Application number: 2026/90484	
What is the application for?:	Change of use from dwelling to C2 for 4 children, erection of first floor extens
Address of the site or building:	143, Church Lane, Gomersal, Cleckheaton, BD19 4QN
Postcode:	LS27 7HB

Type of comment: An objection	
Do you wish your comments to be published on the website anonymously?	Yes
Planning Objection Note – 143 Church Lane, Gomersal Application: 2026/62/90484/E (Children's Care Home, Use Class C2) This objection is submitted on the basis of planning, safety, and safeguarding concerns regarding the proposed use of 143 Church Lane as a children's home. 1. Unsuitable Location and Environment The property is located on a busy main road (Church Lane), which presents inherent safety risks, particularly for children with complex behavioural or emotional needs. The site is characteristic of a family dwelling within a residential setting and lacks the spatial, environmental, and therapeutic qualities expected of specialist residential care provision. The rear of the property directly borders farmland where heavy machinery and livestock are present. This creates a foreseeable and evidenced risk should a child abscond from th

Alterations and Extensions to  
143 Church Lane Gomersal, Cleckheaton,  
BD19 4QN.

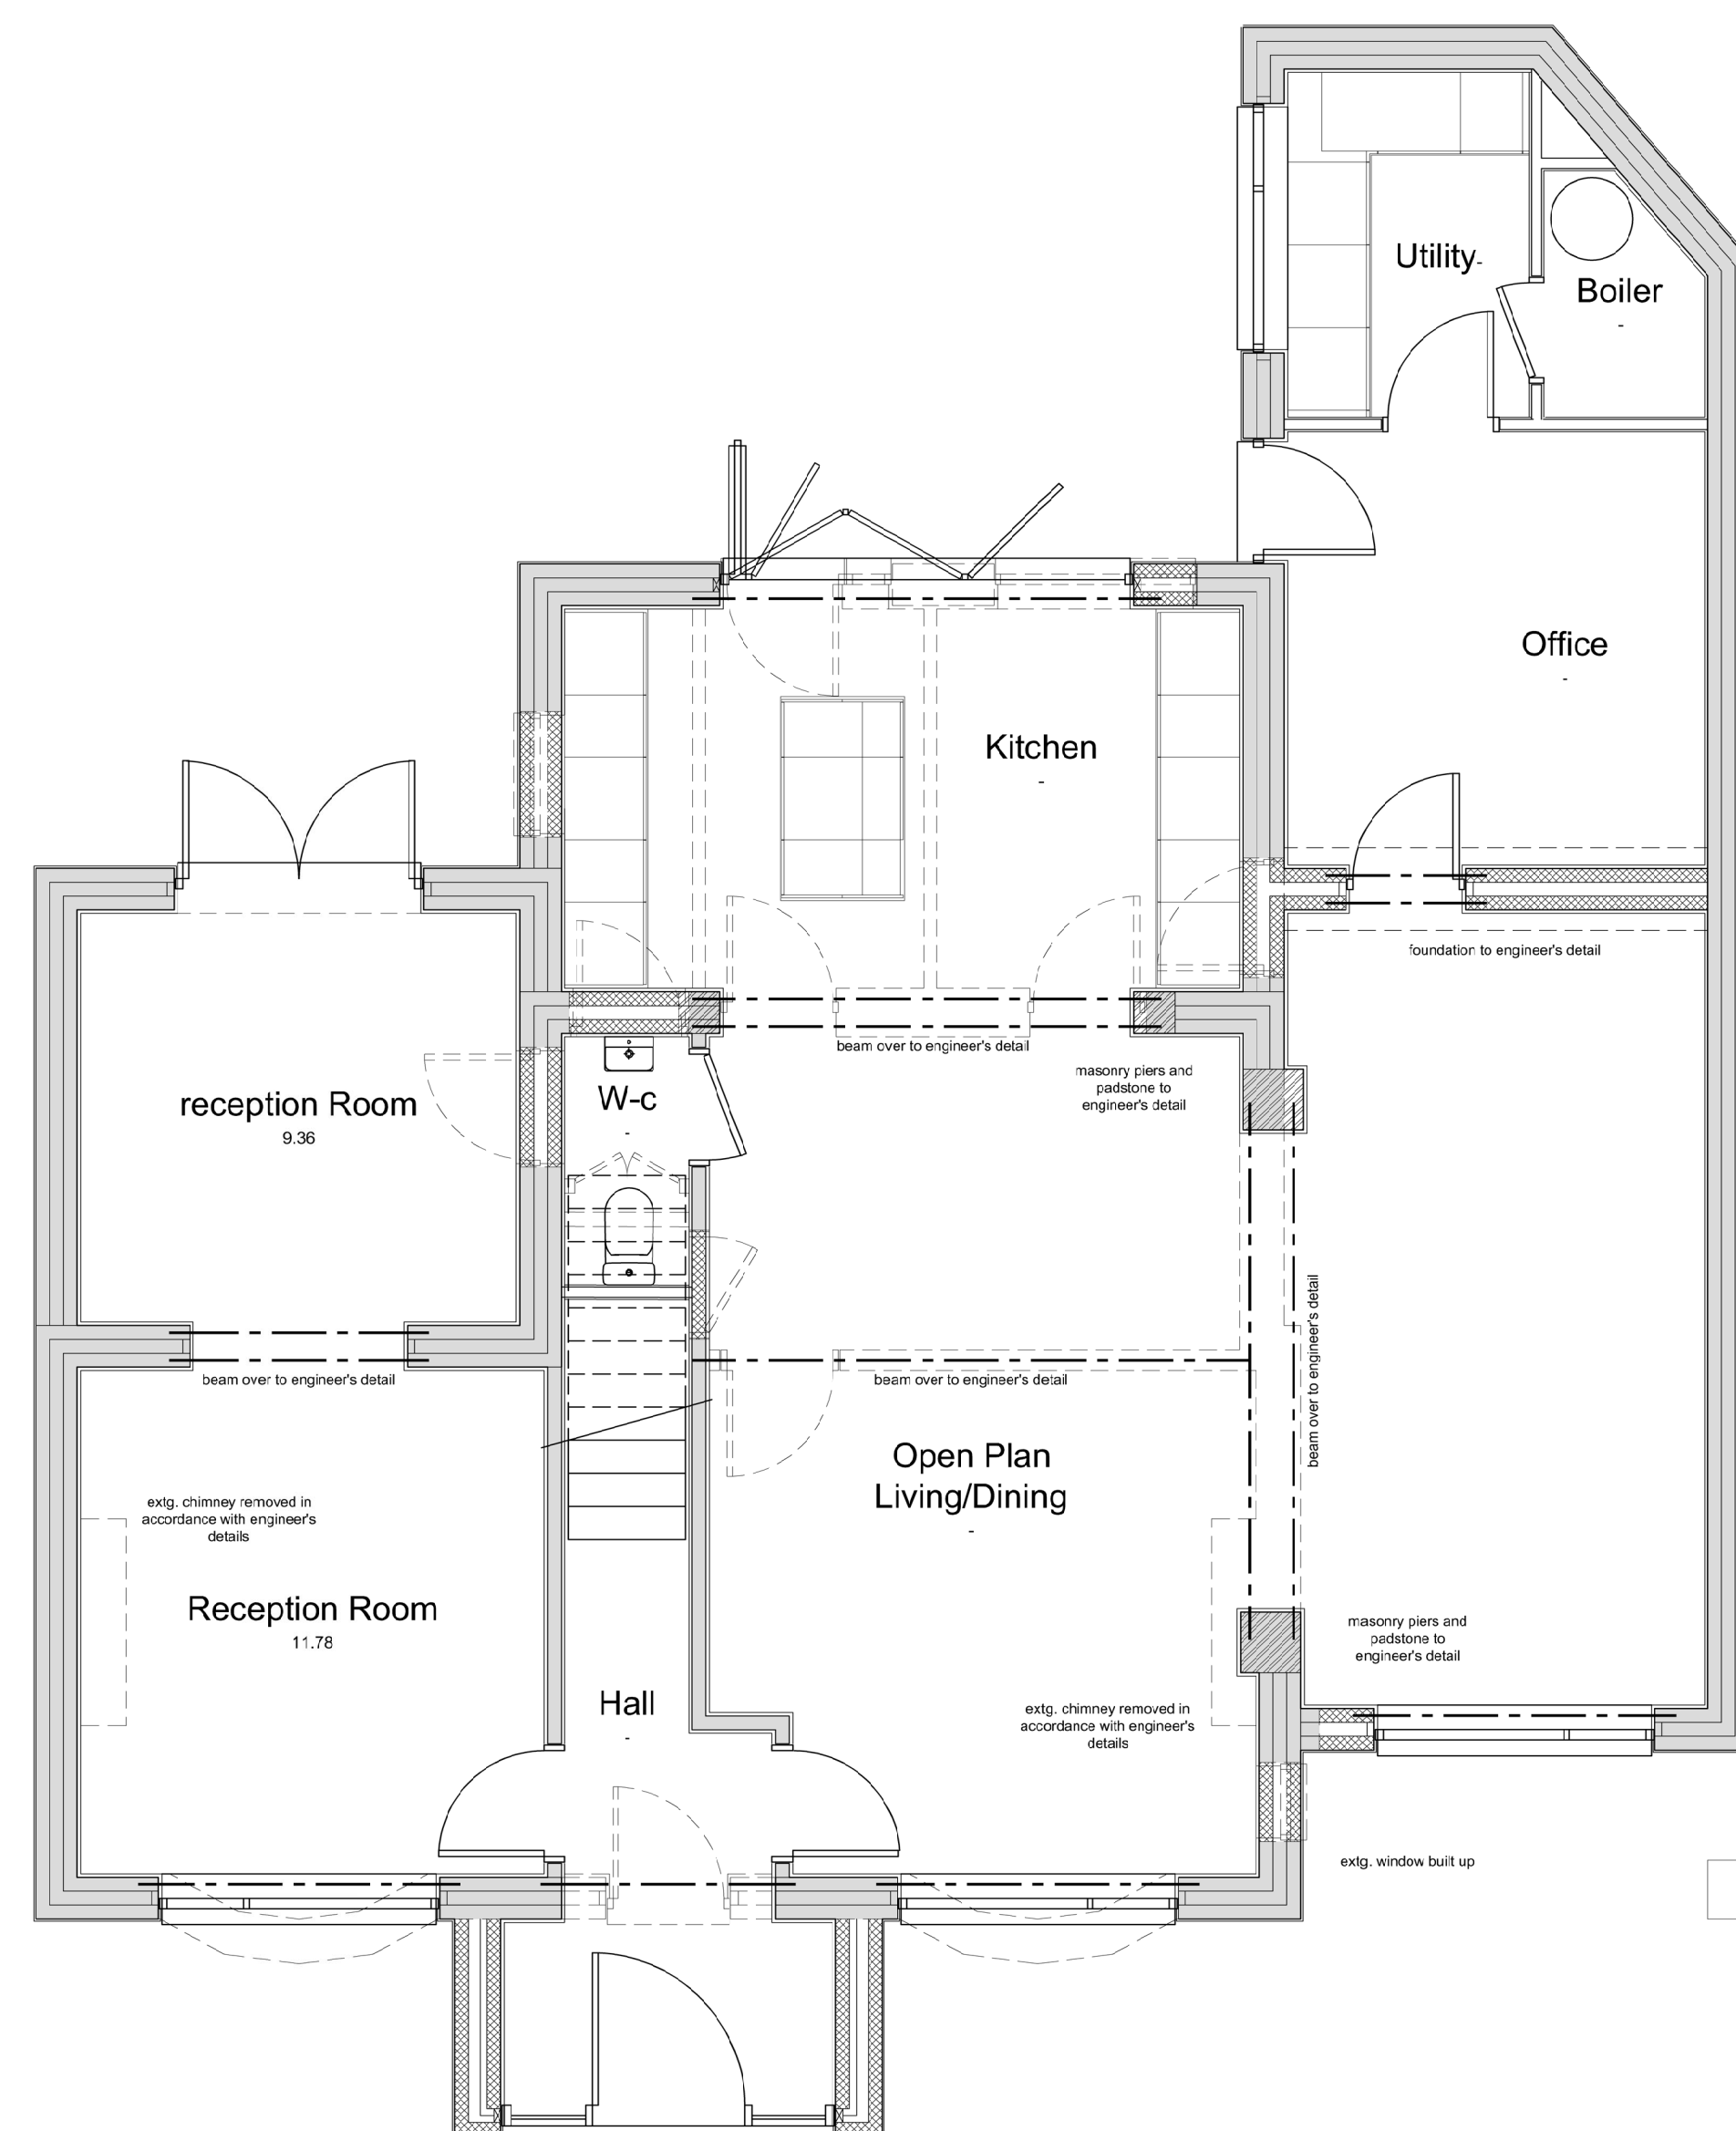
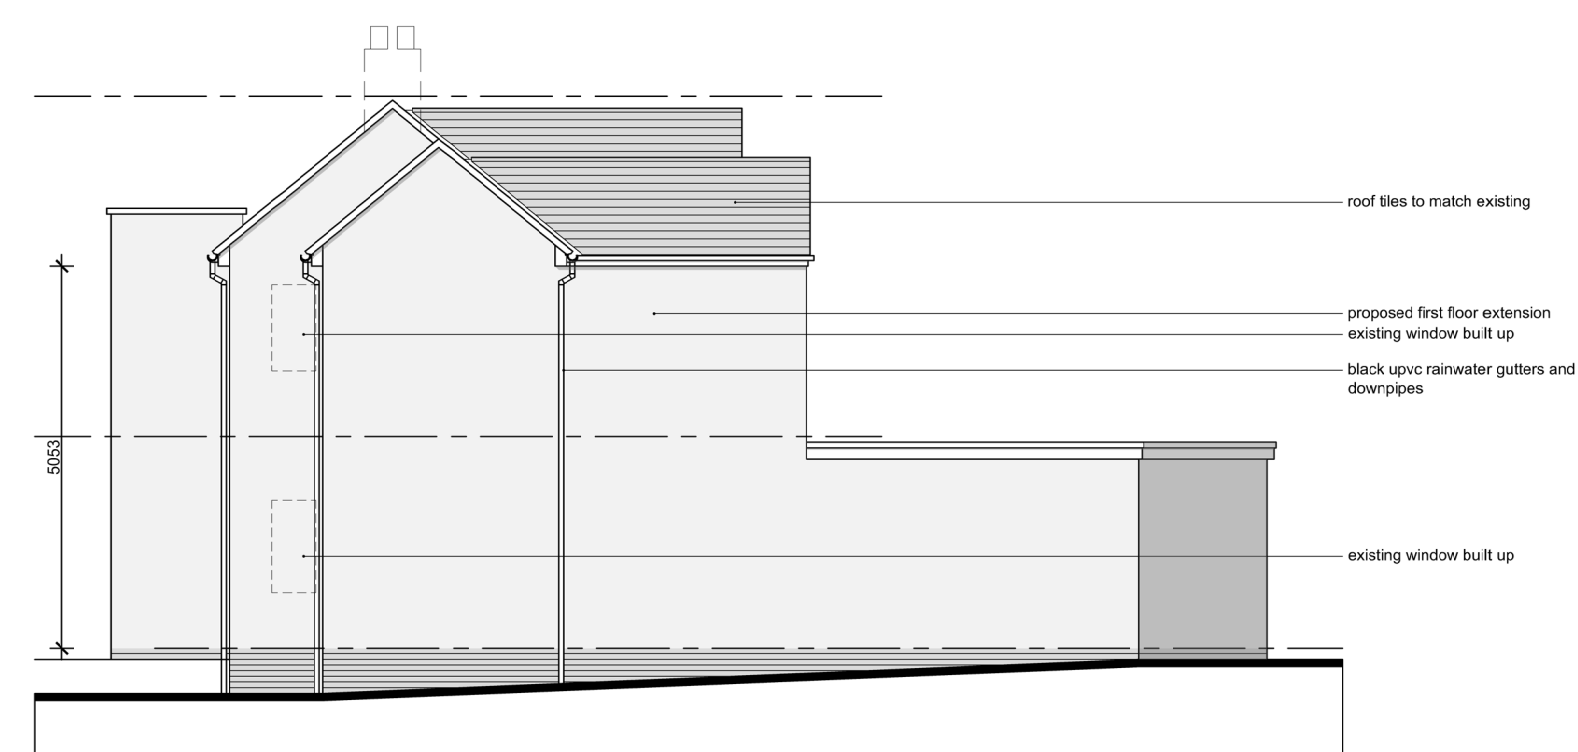
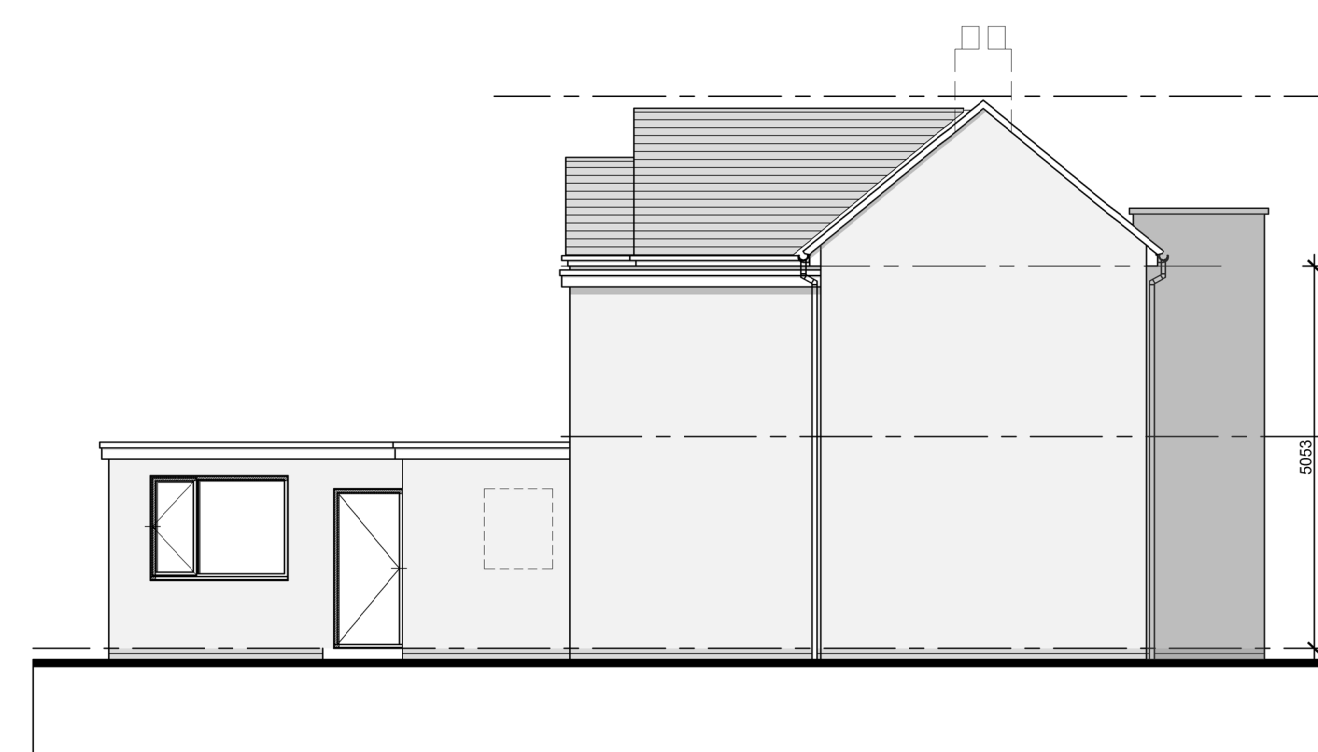
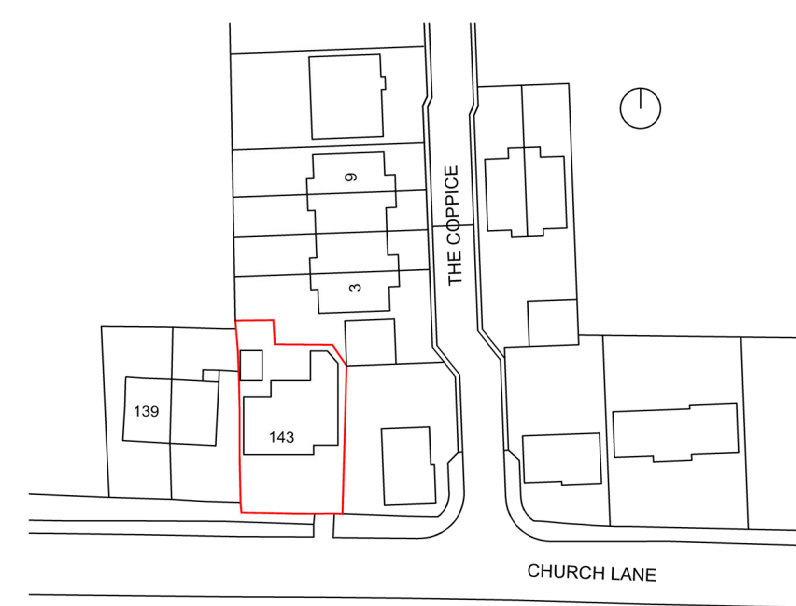
The scale and nature of the proposed use will materially change the character of the area. Additional build above the garage will infringe on privacy and reduced light.
